INSPECTION REPORT

DATE OF INSPECTION: 2/22/2021
COMPANY NAME: Paaru
PROJECT NAME: Holly Ave Construction
LOCATION: 9100 Holly Ave NE ,Albuquerque,New Mexico,87122
TRACKING NO: NMR100000
COMPLIANCE EVALUATION: Marginal
TYPE OF INSPECTION: 14Day
START TIME: 2:45 AM
END TIME: 3:15 AM
INSPECTOR'S NAME: Kasey Anderson
INSPECTOR'S TITLE: Environmental Inspector
INSPECTOR'S QUALIFICATIONS: Storm Water Qualified Person
INSPECTOR'S CONTACT: 505-280-7766
PHASE OF CONSTRUCTION:
☐ Clear and Grub
 ☐ Excavation
 ☐ Building (vertical)
☐ Rough Grading
 ☐ Infrastructure
 ☒ Final Grading
☒ Final Stabilization

CG101

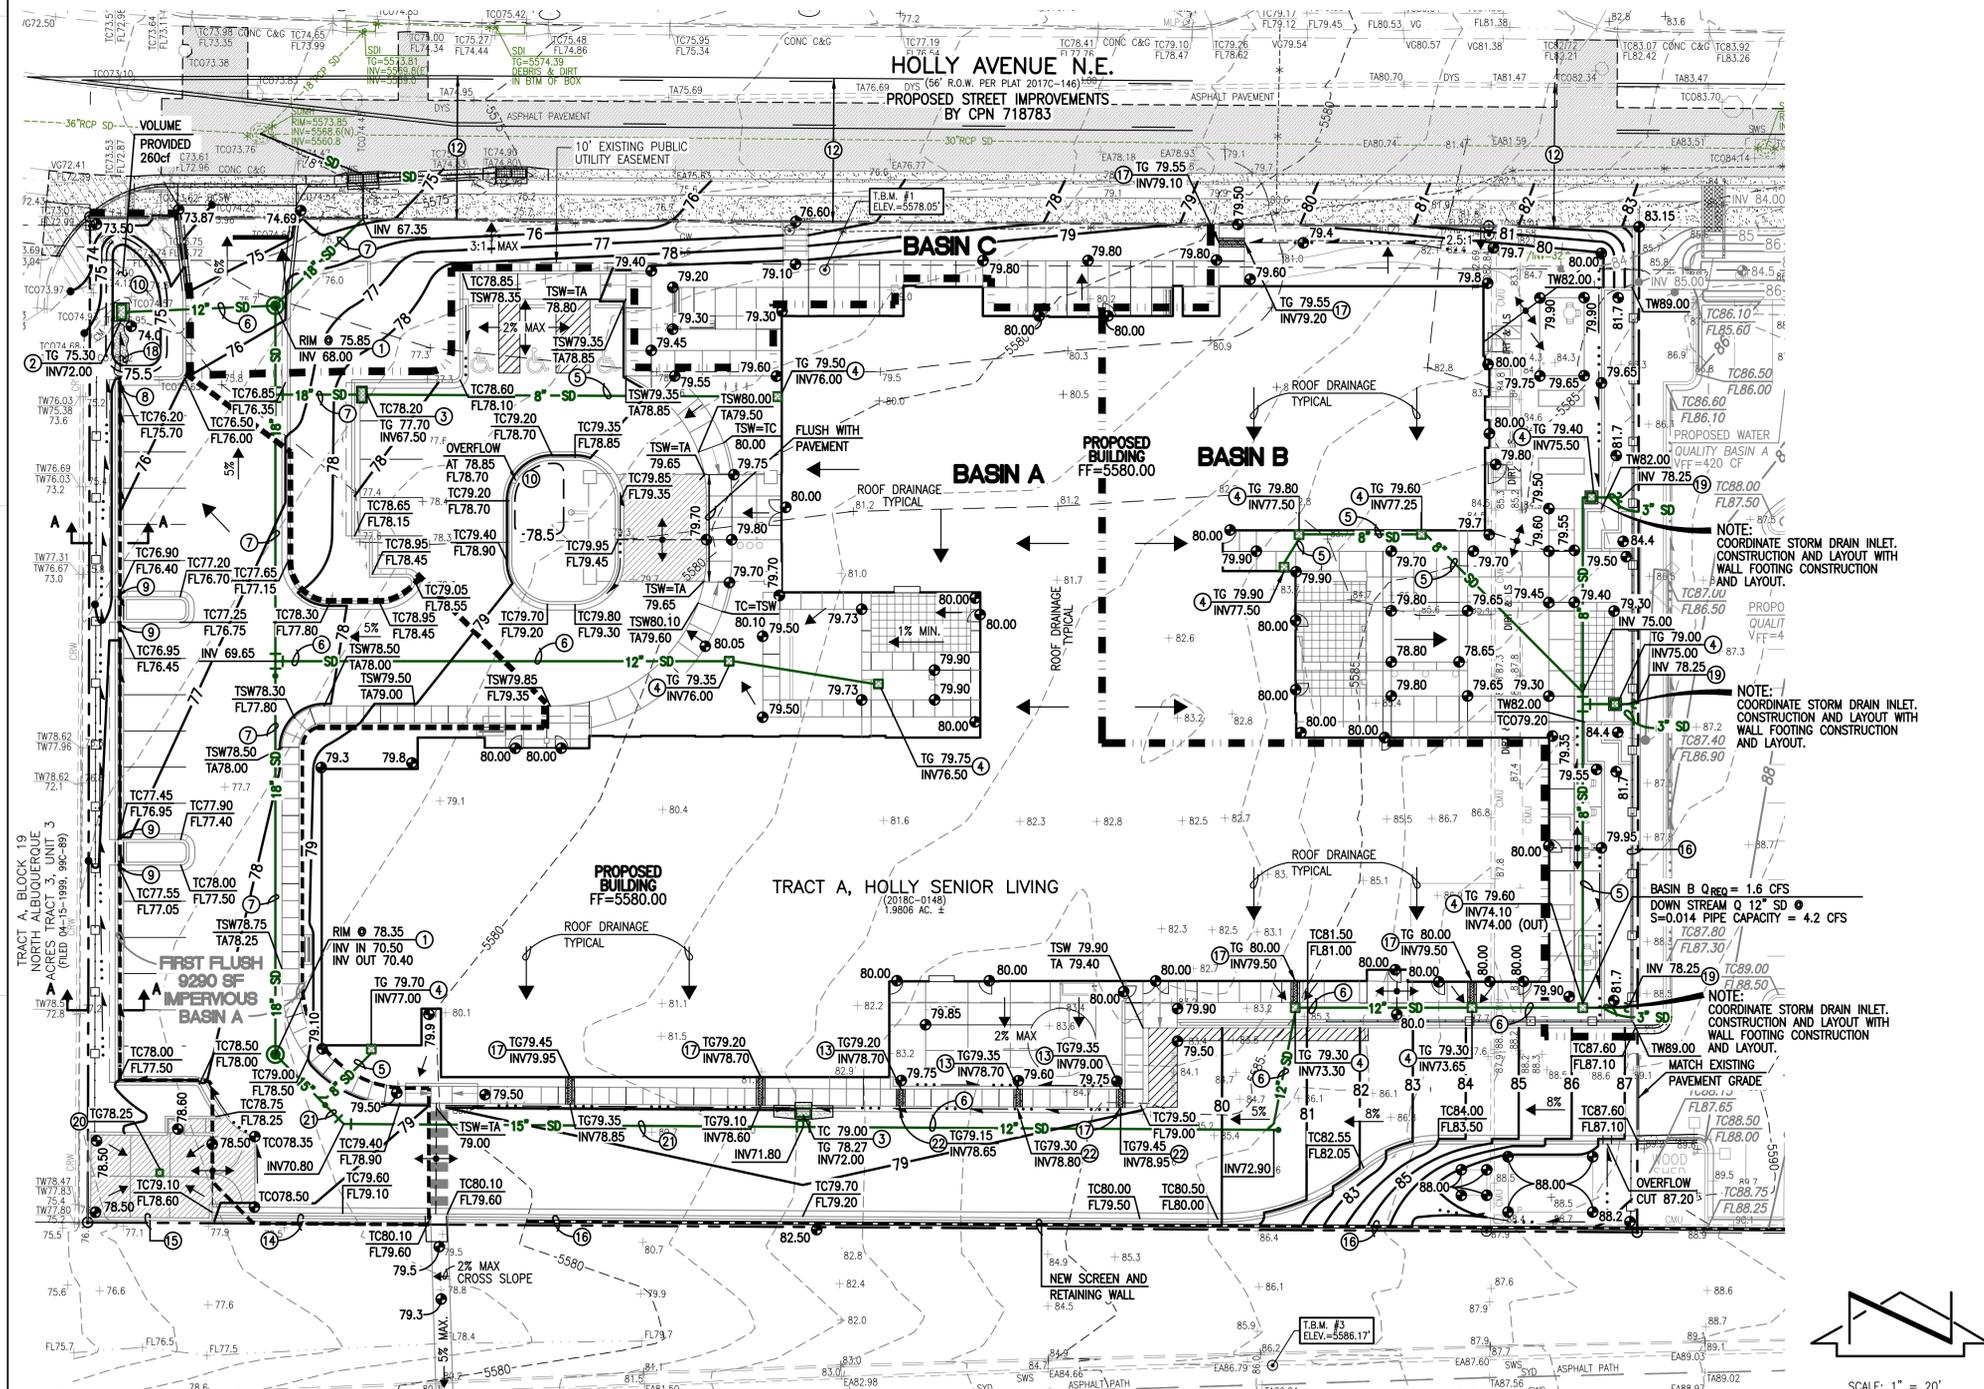
3	Are disturbed areas not actively being worked properly stabilized?	<input type="radio"/> Yes <input checked="" type="radio"/> No <input type="radio"/> N/A	<input checked="" type="radio"/> Yes <input type="radio"/> No	Even though a lot of the site has rock, concrete, or asphalt as the final stabilization, areas that are not finished and could flow into the many inlets that are not on the street include; E parking lot stockpiles and wall area, E courtyard, S courtyard, and SE electric box slope. I talked with Mike Hart, and he said that the site would have the rest of the landscaping and paving finished this week.
4	Are natural resource areas (e.g. streams, wetlands, mature trees, etc.) protected with barriers or similar BMPs?	<input type="radio"/> Yes <input checked="" type="radio"/> No <input type="radio"/> N/A	<input checked="" type="radio"/> Yes <input type="radio"/> No	Two new stockpiles in the eastern parking lot. Add wattles across the detention pond opening and the north side of the NW stockpile. Re-install inlet protections on Holly Ave southern curb until the E stockpiles are removed. Clean up sediment and debris buildup around the inlets. Re-install inlet protection on the curb inlet on the south side of the building.

5	Are discharge points and receiving waters free of any sediment deposits?	<input type="radio"/> Yes <input checked="" type="radio"/> No <input type="radio"/> N/A	<input checked="" type="radio"/> Yes <input type="radio"/> No	Re-install inlet protections on Holly Ave southern curb until the E stockpiles are removed. Clean up sediment and debris buildup around the inlets.
